REQUEST

Current Zoning: R-3LWPA (single family residential, Lake Wylie Protected Area)
Proposed Zoning: R-8MF(CD)LWPA (multi-family residential, conditional, Lake Wylie Protected Area)

Approximately 11.23 acres located at the southeast intersection of Oakdale Road and Mt. Holly-Huntersville Road, north of Interstate 485

The petition proposes to redevelop 4 large single family lots with up to 88 single family attached units as a second phase of development approved for the adjacent site to the east in northwest Charlotte.

REZONING PETITION #2022-170
SCHEMATIC SITE PLAN

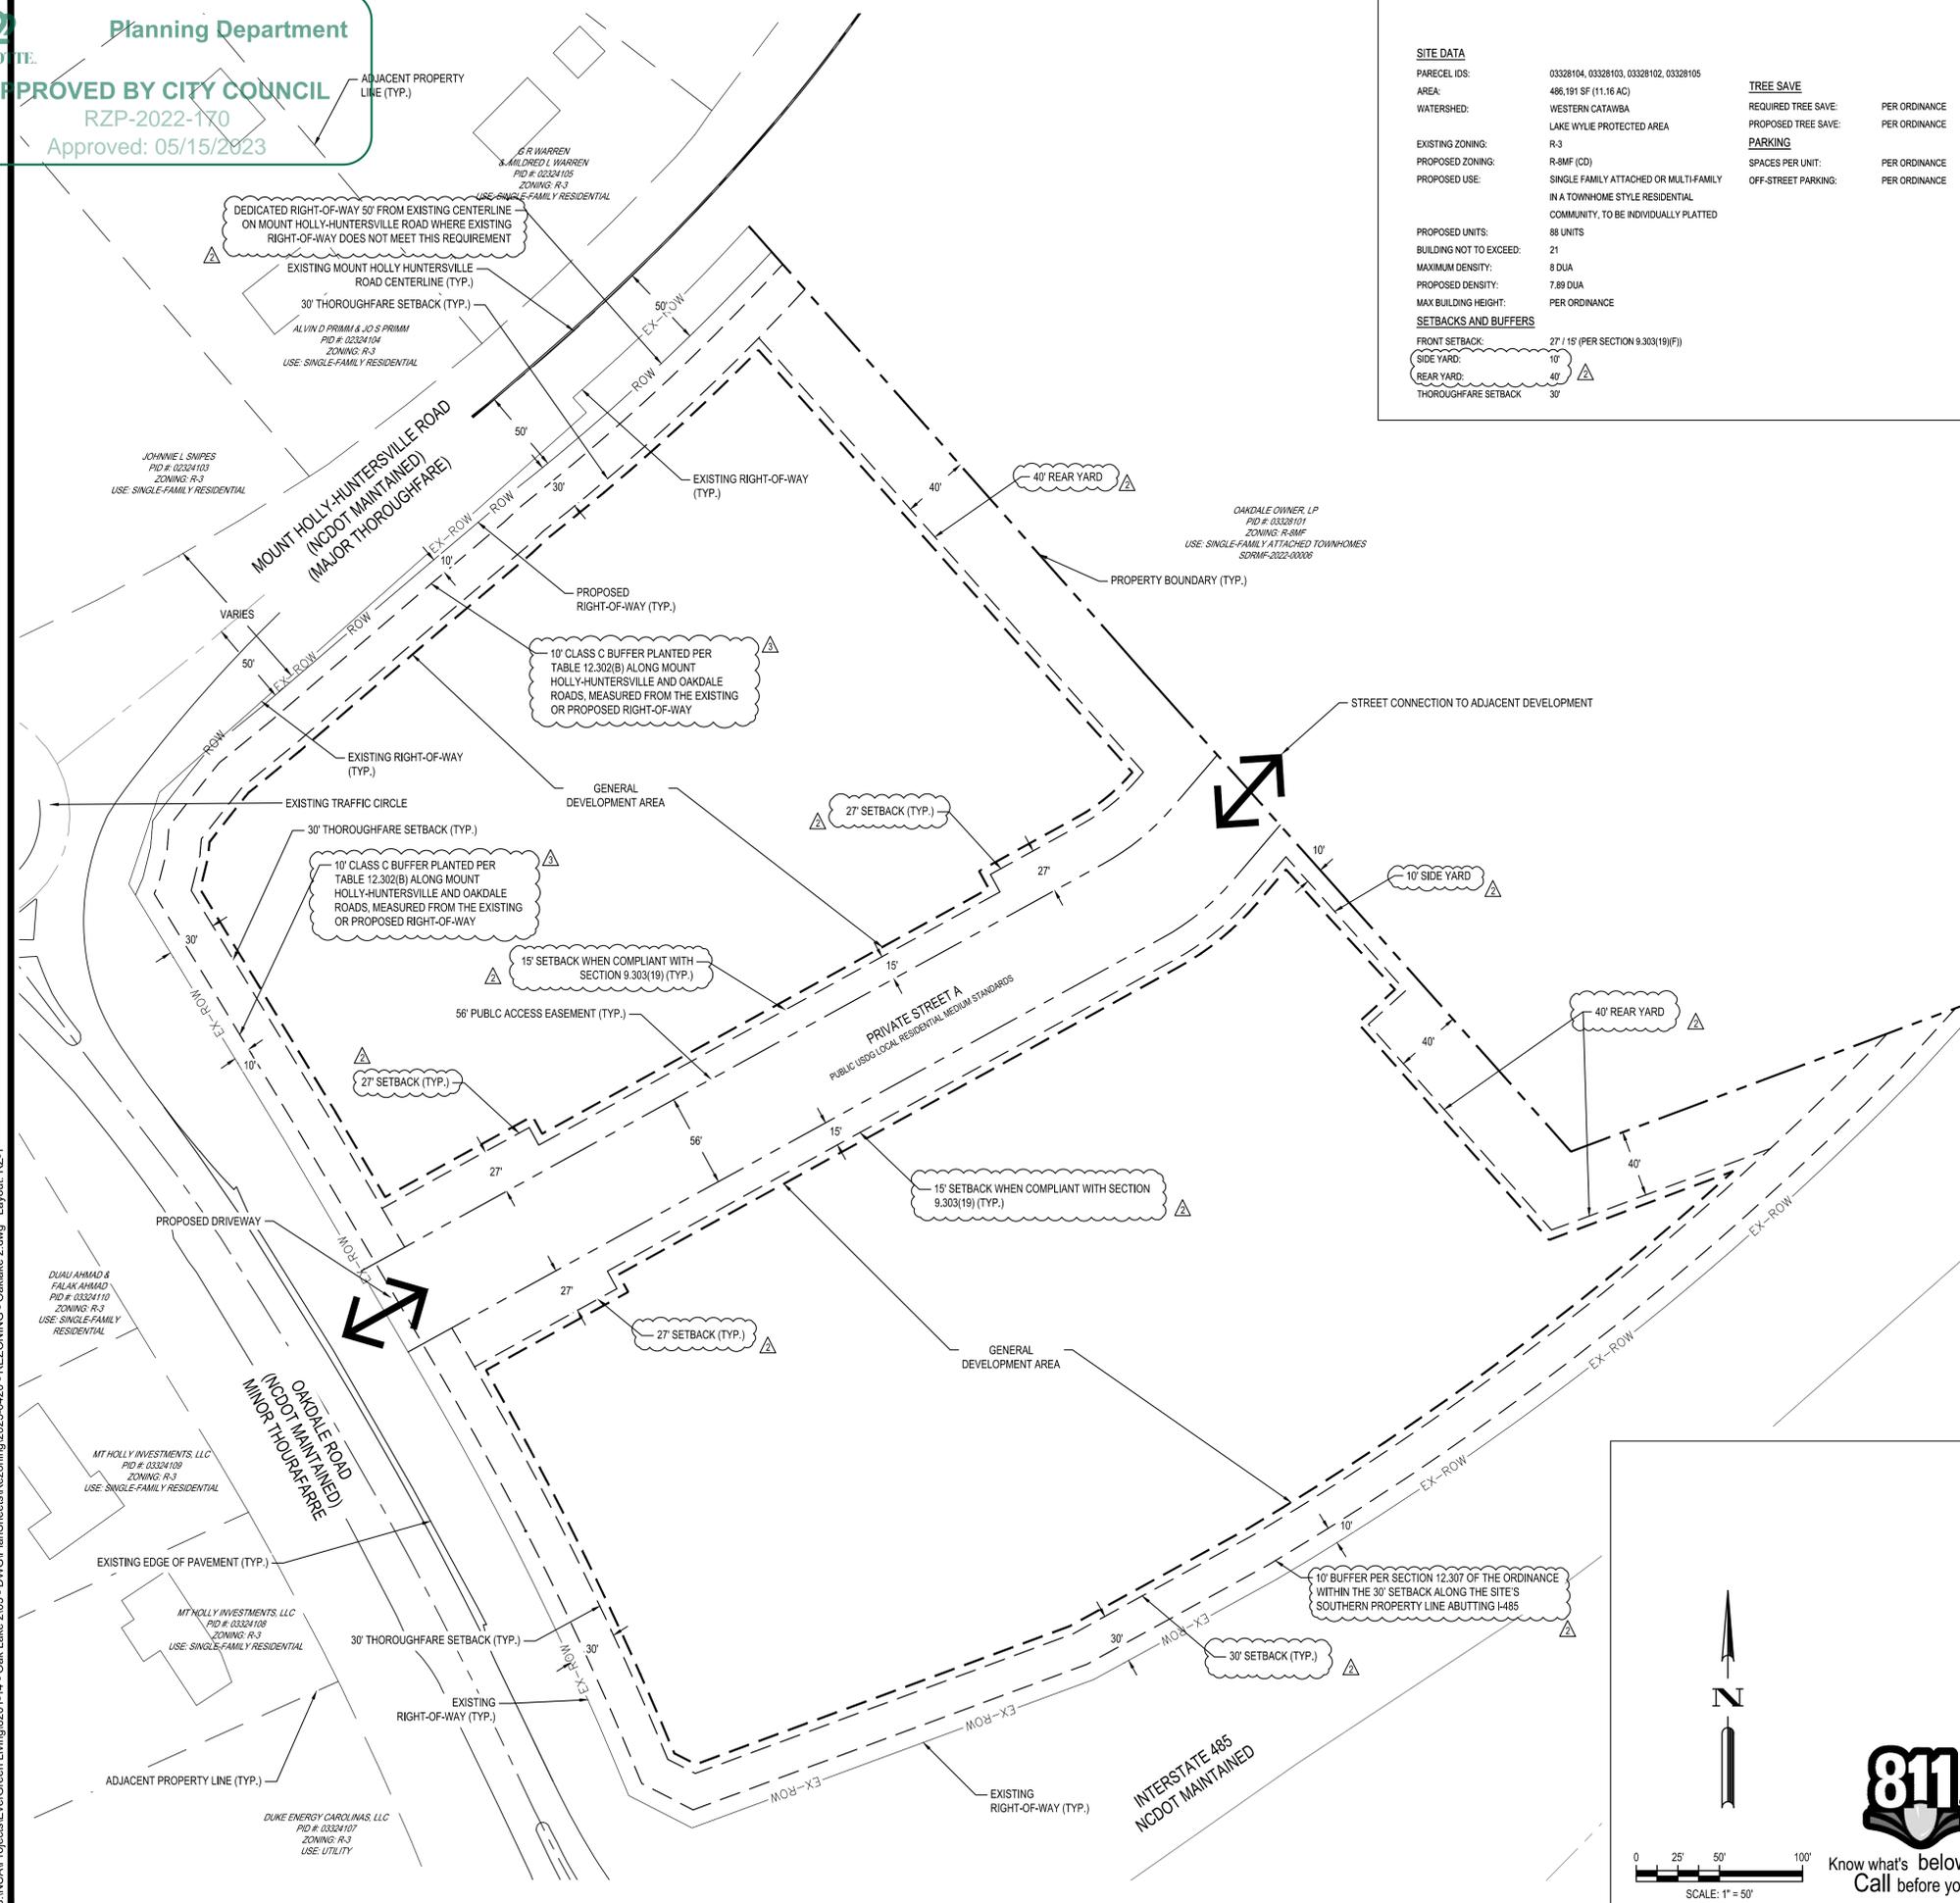
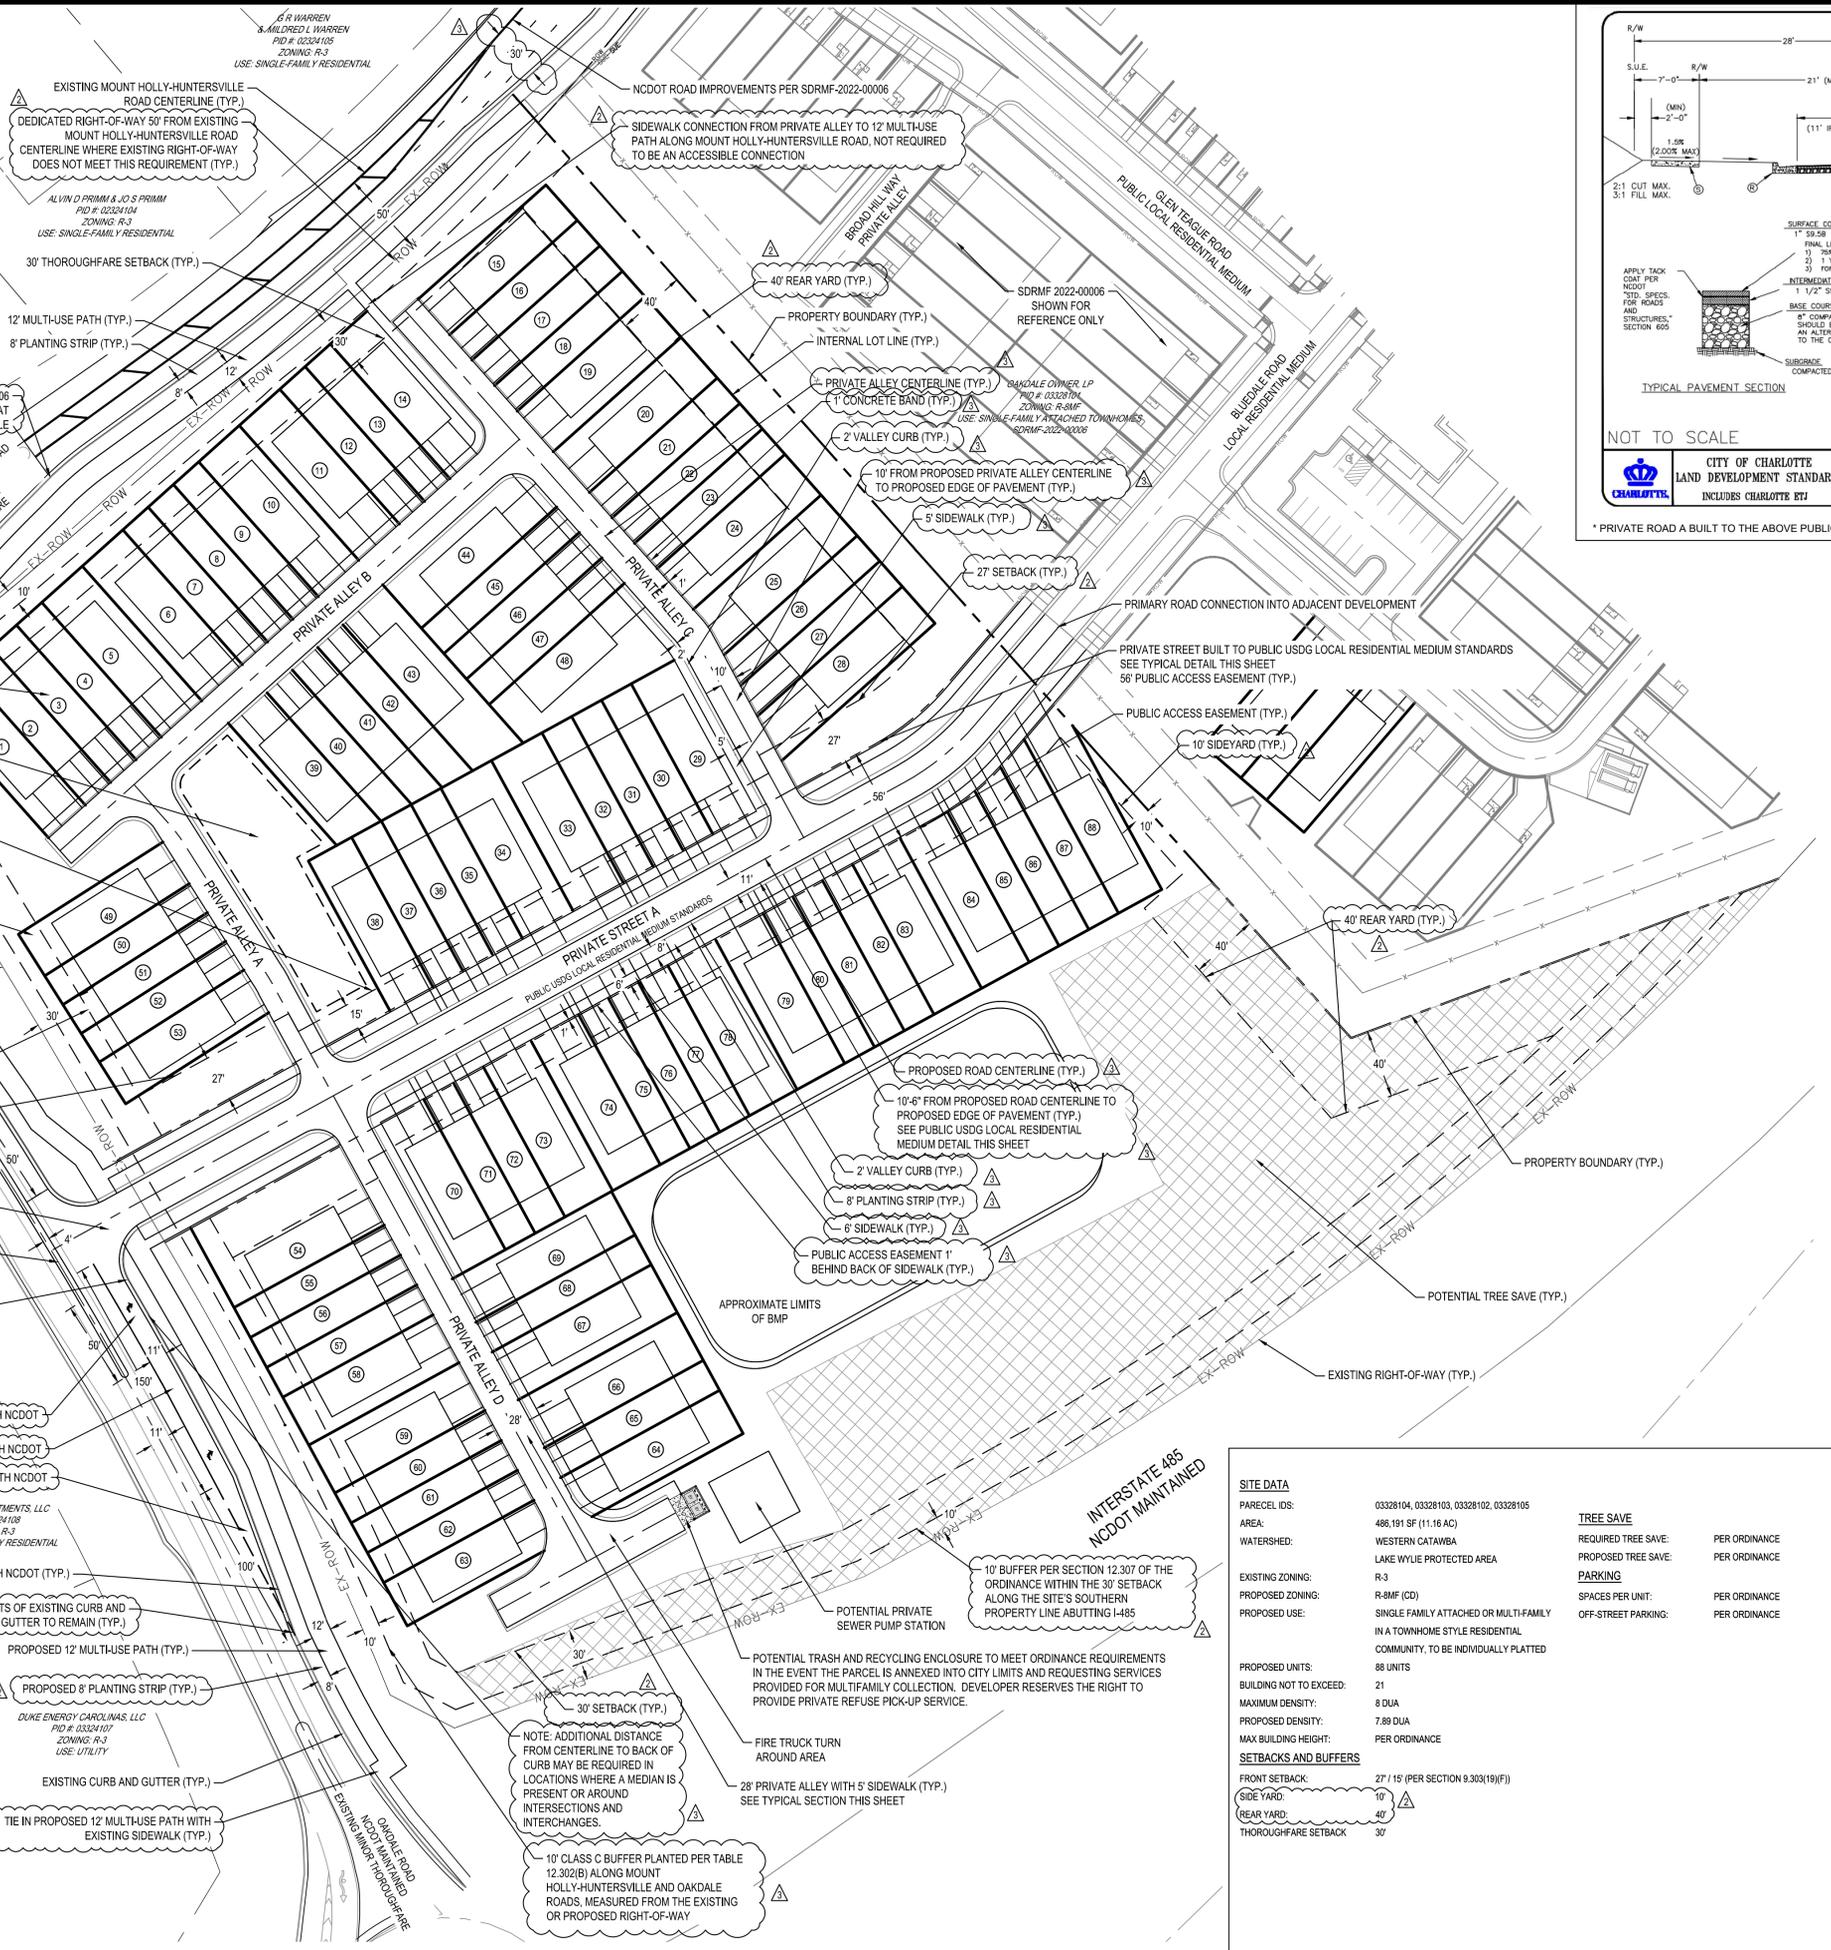
5. ~~Label and dimension the curb and gutter from the centerline for each road on the site plan.~~ Addressed
6. ~~Location of curb and gutter along Mt. Holly Huntersville Rd. to be moved 30 ft from roadway centerline to accommodate Charlotte Streets Map with a section of 4+ Avenue and shared use path.~~ Addressed

7. ~~Label and dimension internal street infrastructure including curb line, sidewalks, plantings strips and right-of-way.~~ Addressed
8. ~~Add a conditional note specifying "A Right of Way Encroachment Agreement is required for the installation of any non-standard item(s) (irrigation systems, decorative concrete pavement, brick pavers, etc.) within a proposed/existing city-maintained street right-of-way by a private individual, group, business, or homeowner's/business association. An encroachment agreement must be approved by CDOT prior to construction/installation. Contact CDOT for additional information concerning cost, submittal, and liability insurance coverage requirements."~~ Addressed

11. ~~Remove driveways from CDOT 50'x50' sight triangles areas connecting to Street A.~~ Addressed
